CITY OF ALBUQUERQUE

October 4, 2022

**RE: 13554 Elena Gallegos
Grading and Drainage Plan
Engineer's Stamp Date: 9/02/2022
Hydrology File: E24D002B**

C 2

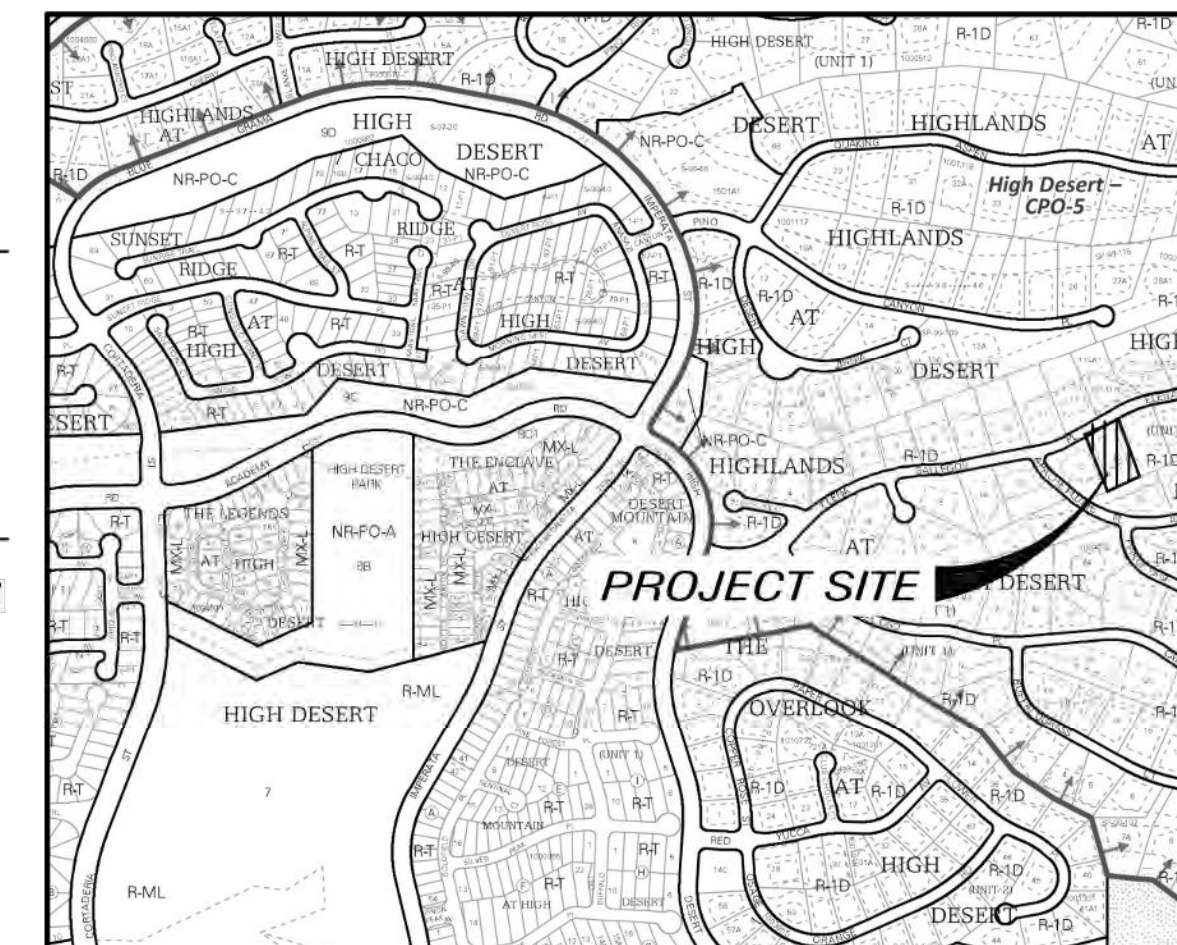
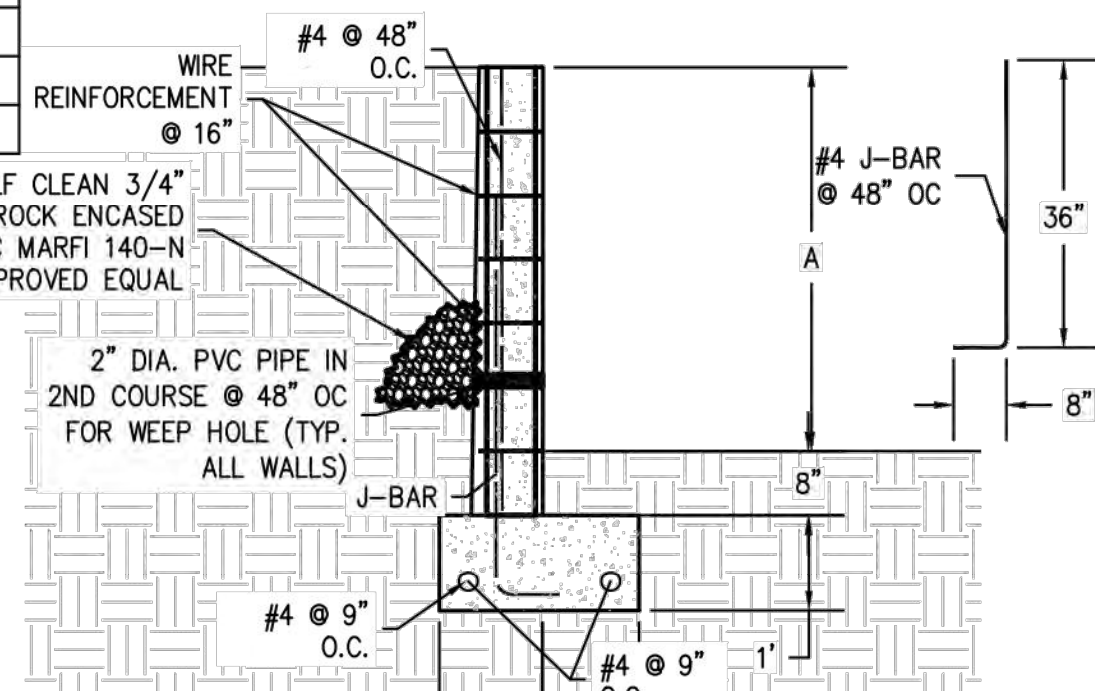
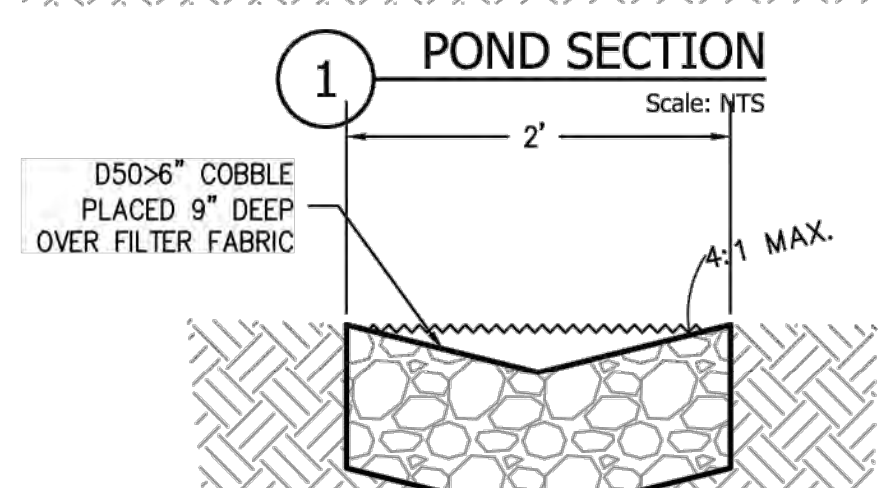
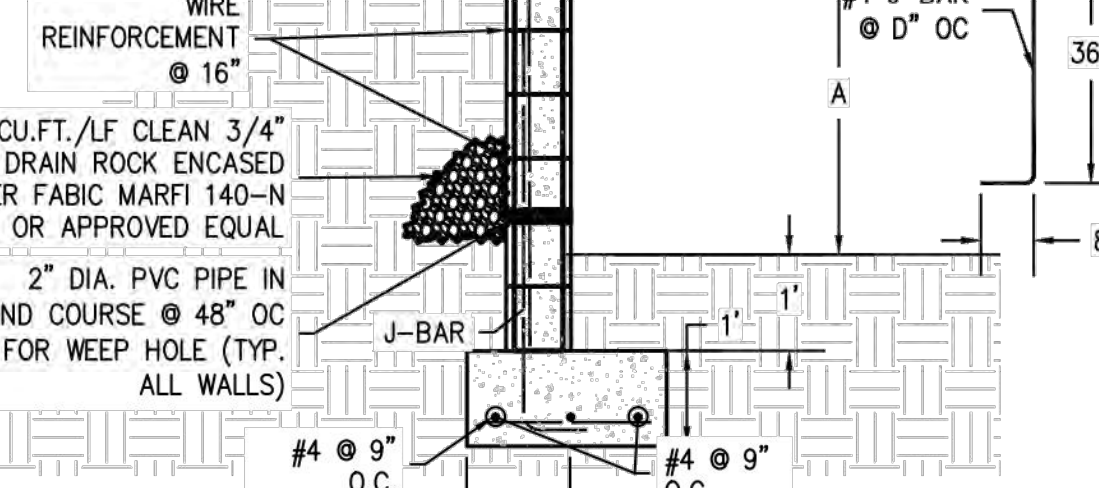
1. Pad Certification will be required prior to building permit approval.
2. Retaining wall must be permitted under a separate permit. Wall if constructed with preparation of pads must be certified prior to building permit as well.
3. Additional riprap may be need between the first wall and second wall at the southwest corner of the property.
4. Additional slope protection may be needed to the east near the southeast corner of the building where concentrated runoff of 0.87 cfs is draining over slope
